STAGE 2 ROAD SAFETY AUDIT

BRADLEY MEADOWS, BRADLEY

Job No: 21041

September 2024

UPPER QUARRY ROAD, DEIGHTON
 PROPOSED HIGHWAY WORKS
 GENERAL ARRANGEMENT

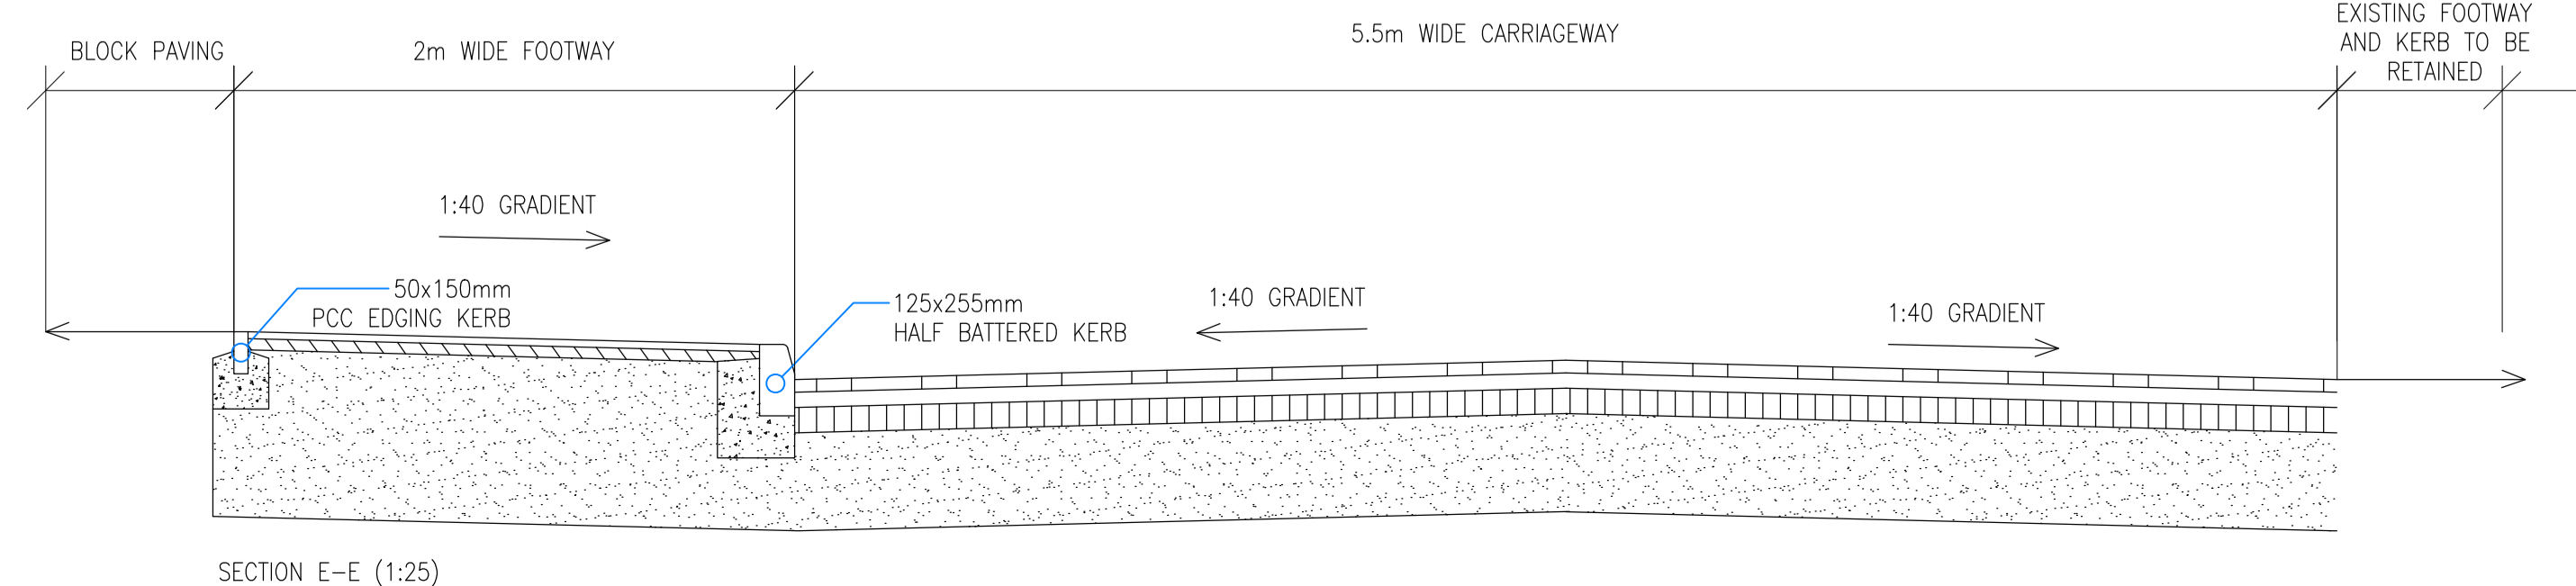
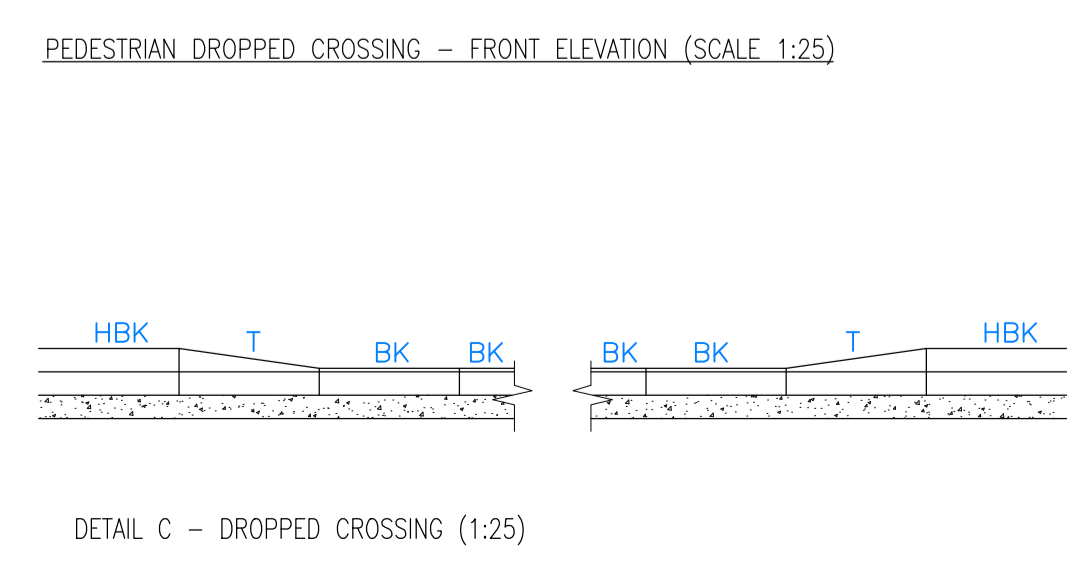
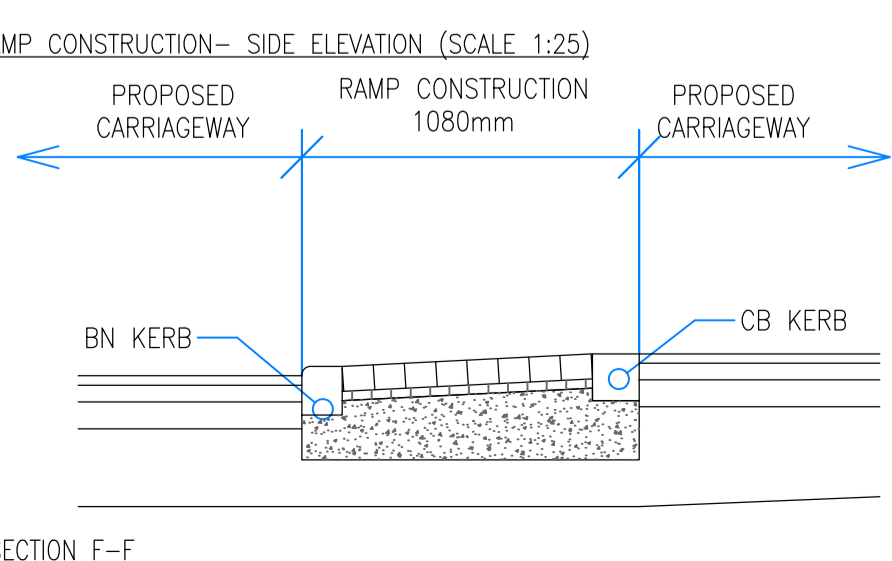
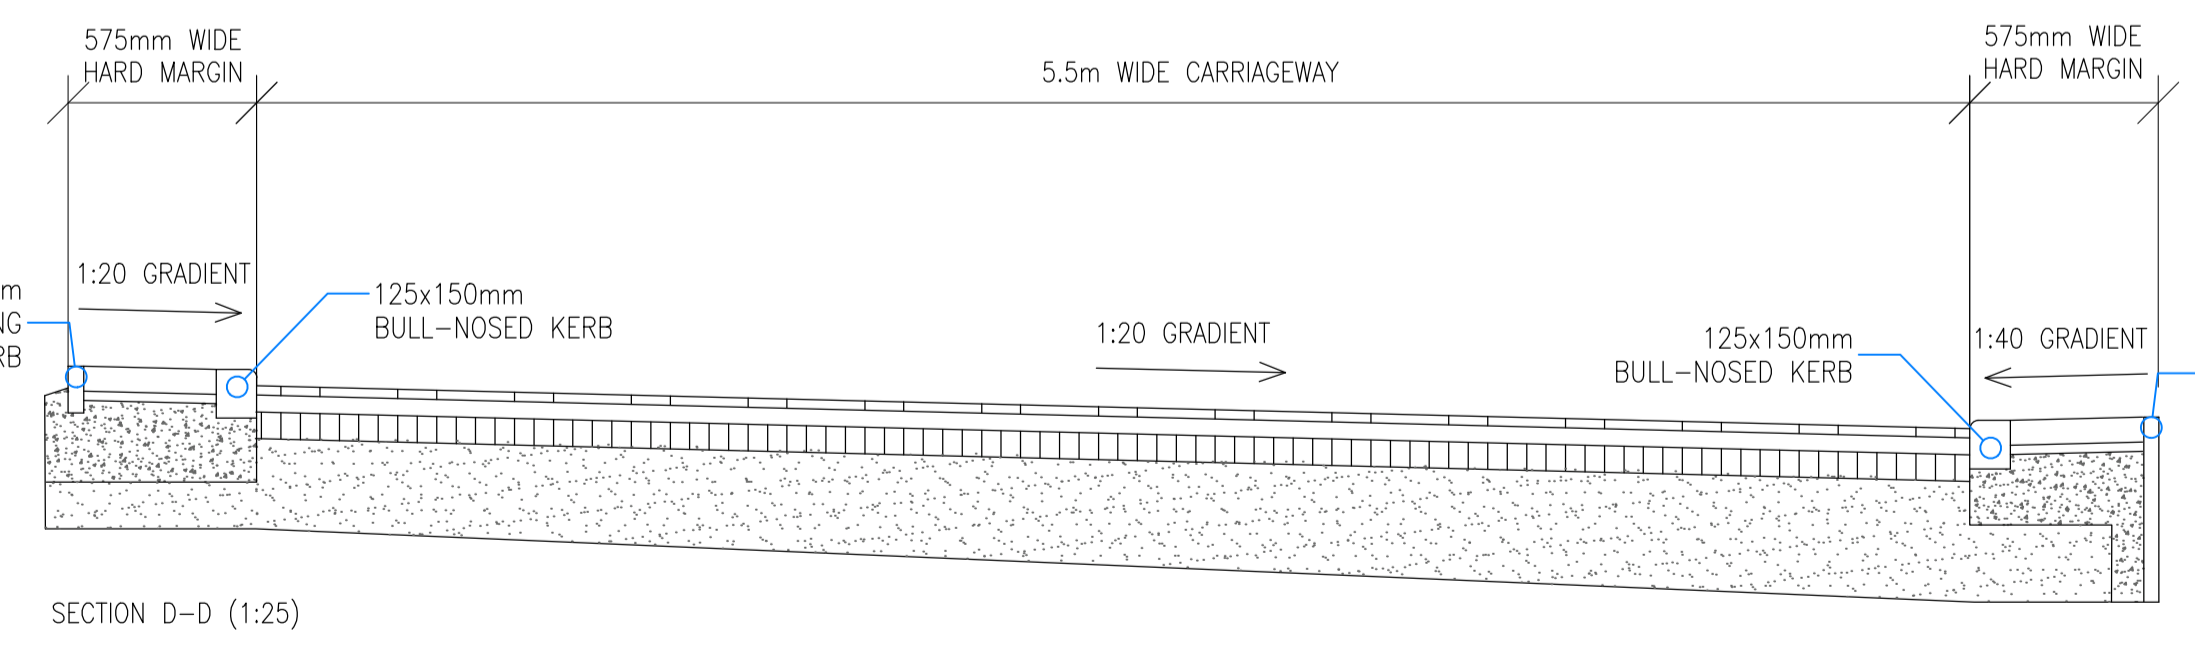
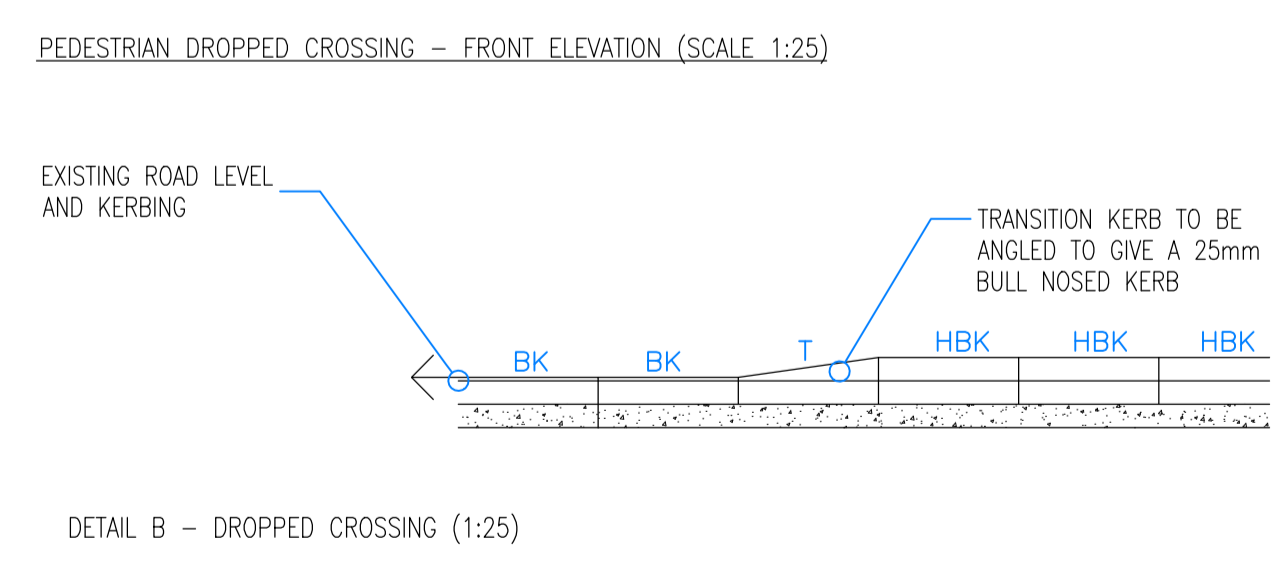
Problem 1	
Location	Crossing point on the eastern side of the access.
Summary	Ponding water that freezes in cold weather could result in pedestrians slipping and falling.
<p>An examination of the existing levels in the vicinity of the crossing point on the eastern side of the access leads to the assumption that there may be a low point in the vicinity of the crossing point and the proposed tactile paving on this side of the access. There is evidence that water ponds in this area in wet weather.</p> <p>The design appears to rely on an existing gully on this side of the access which is blocked/not visible on the ground.</p> <p>If adequate carriageway drainage is not provided this could lead to ponding water which, if it freezes in cold weather, could result in pedestrians slipping and falling.</p>

Recommendation	
<p>Ensure that adequate carriageway drainage is provided around the junction to ensure that water does not pond in the vicinity of the crossing point of the Bradley Road footway across the proposed site access.</p>
